Recommendation Report for Planning Permission for Works or Extension to a Dwelling

REF NO: R/106/21/HH

LOCATION: 26 Tennyson Avenue
Rustington
BN16 2PH

PROPOSAL: Erection of single storey rear extension and hip to gable loft conversion with 1 x side dormer

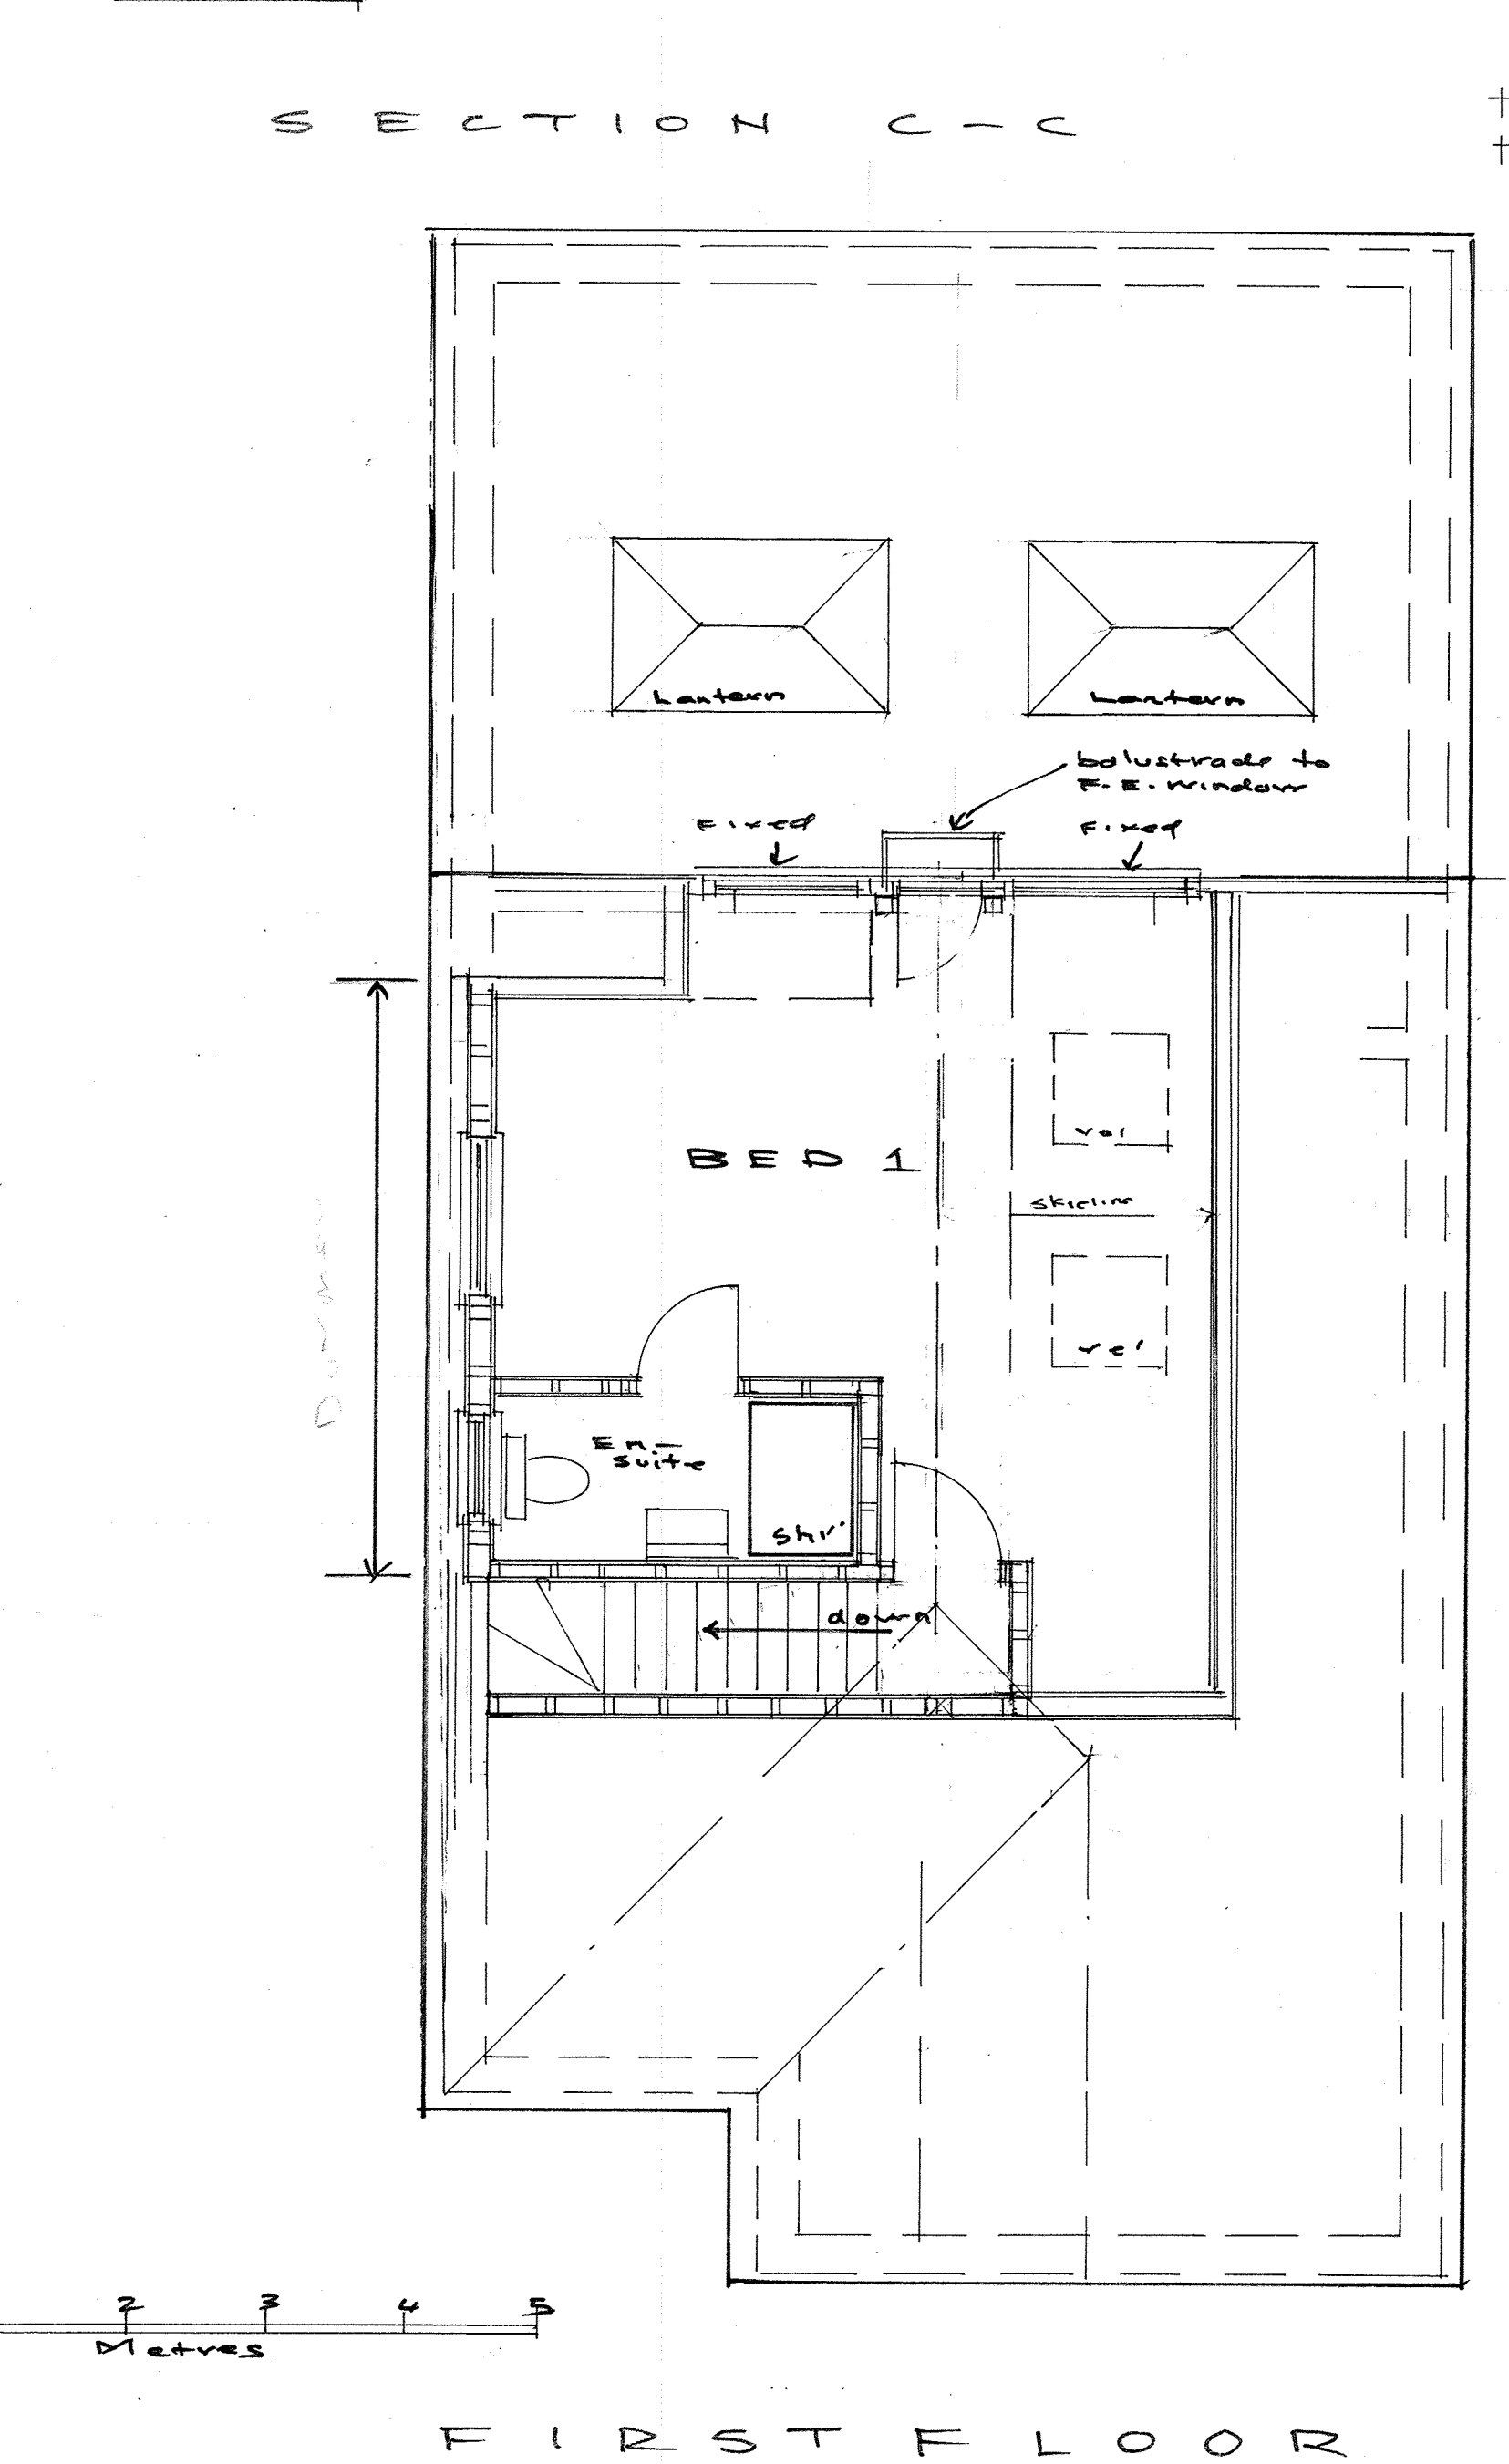
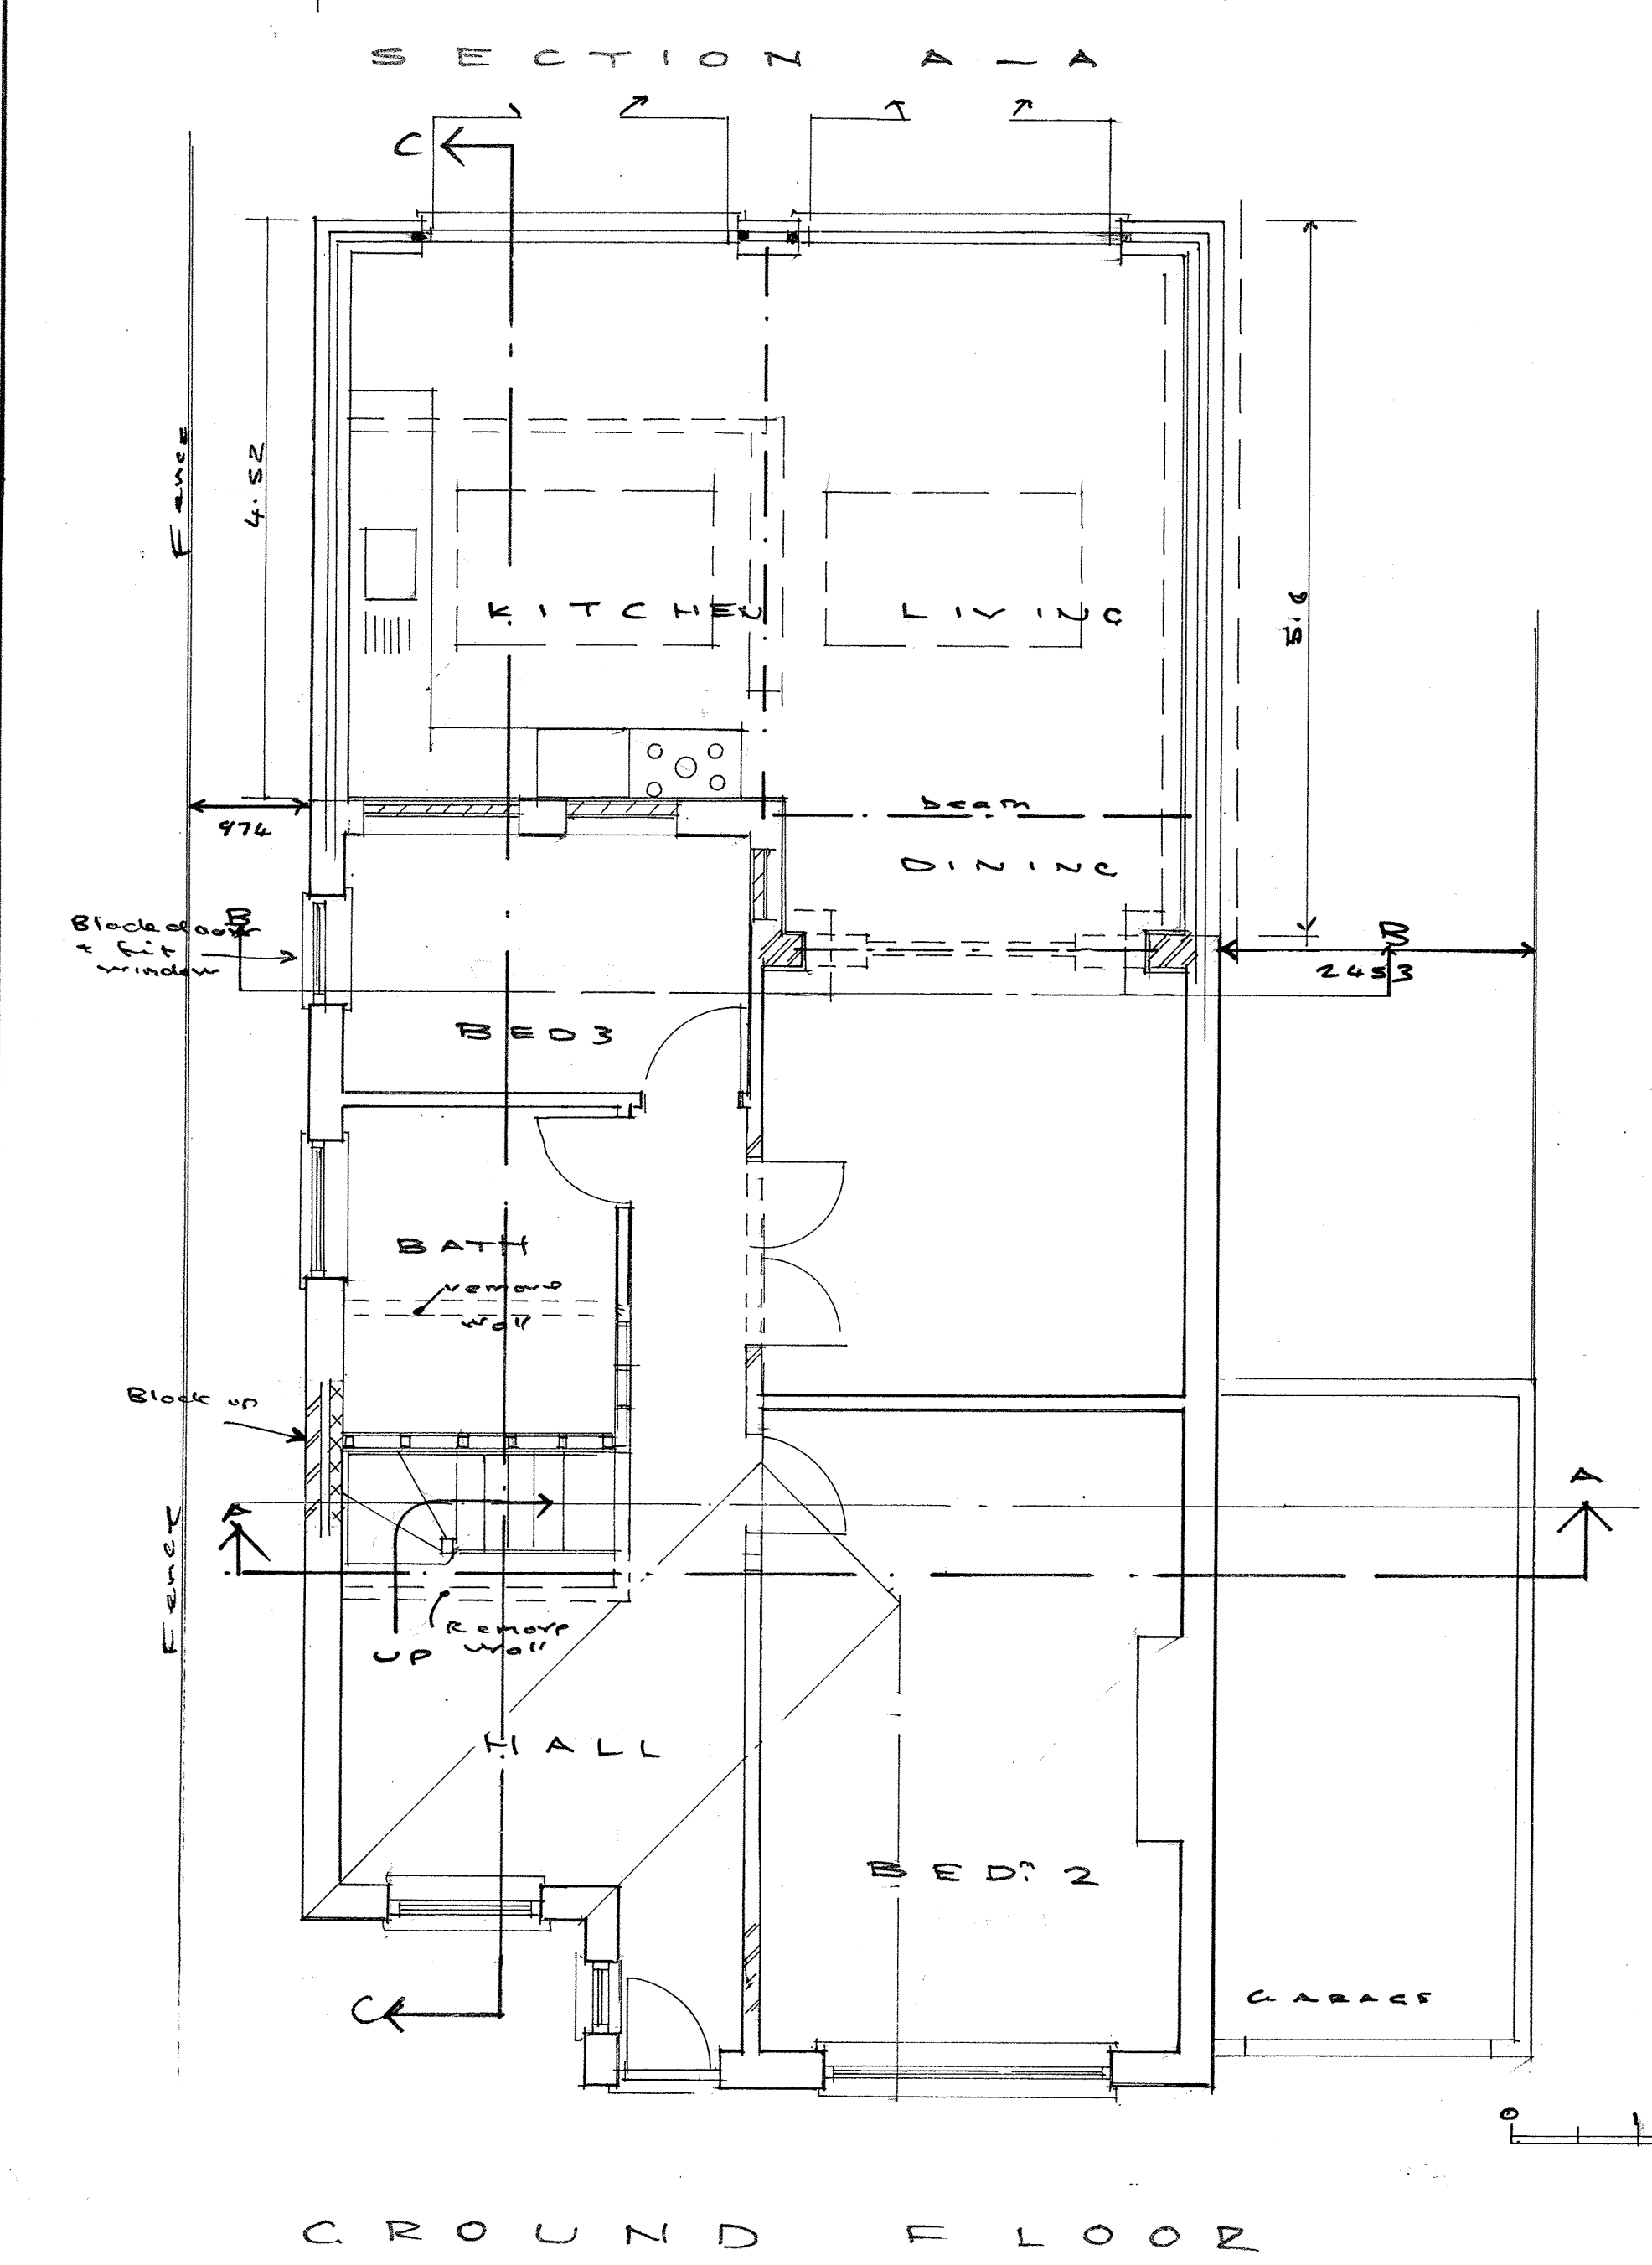
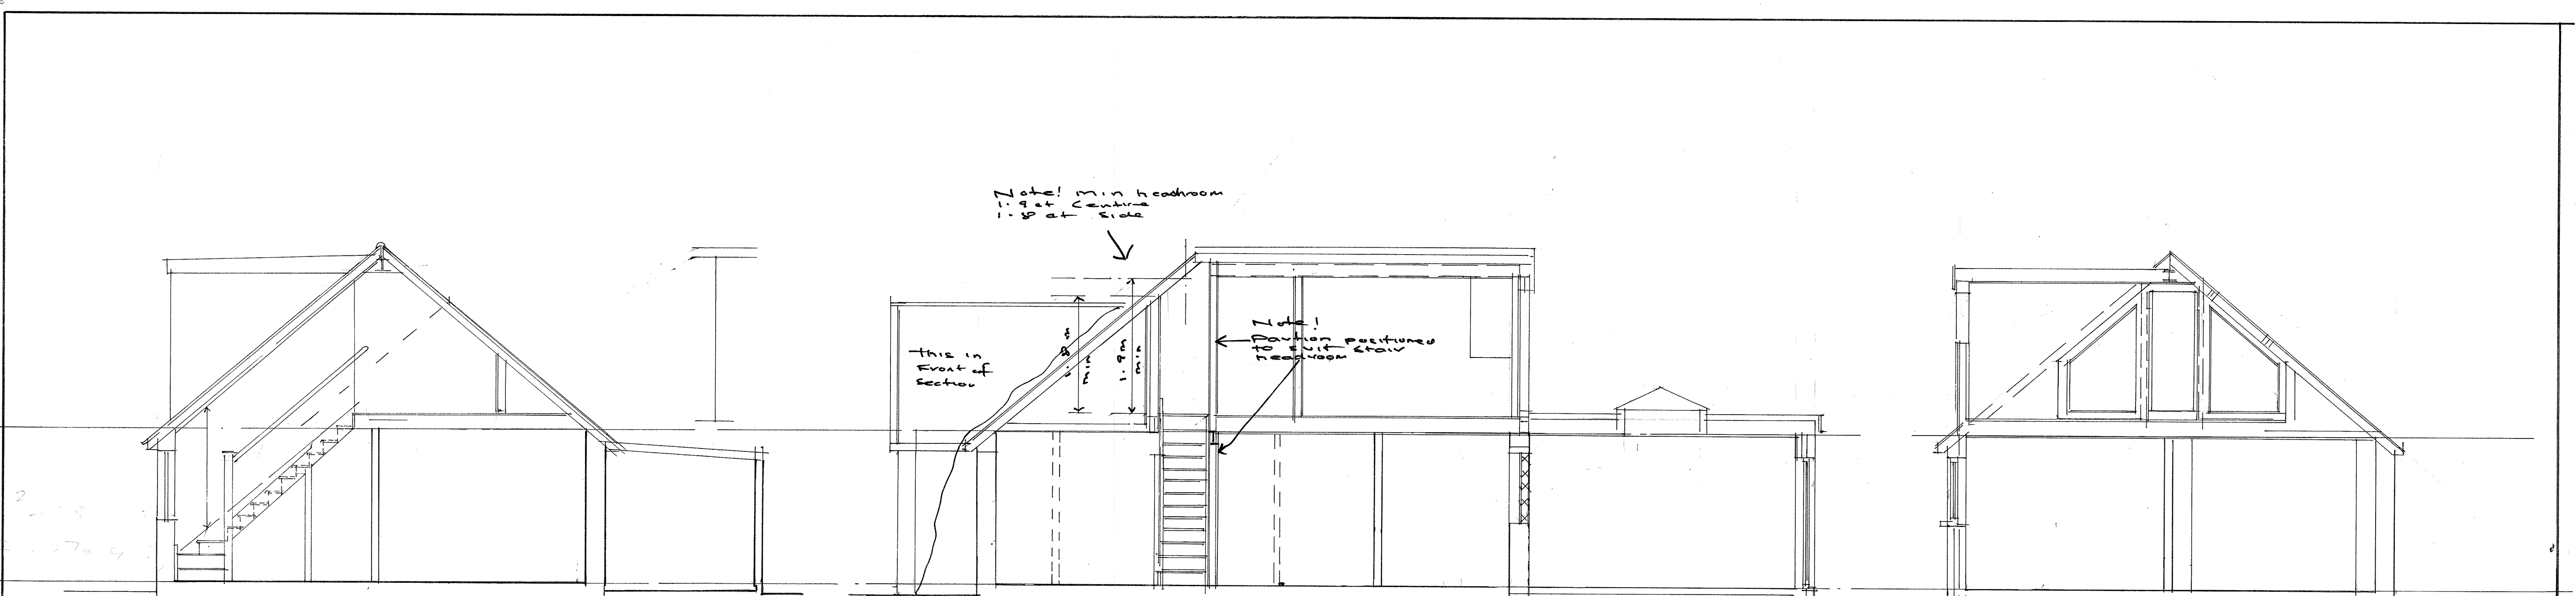
The proposal seeks a ground rear extension and the conversion of the loft with associated dormer window. The size of the extension is appropriate for its intended use and a suitable scale when compared with the plot size.

In terms of the extension, it is not thought that this will be overbearing or overshadow the neighbours to the north or south. The extension will not encroach on the separation gap between either neighbour. The extension complies with the 45-degree rule and has adequate rear garden.
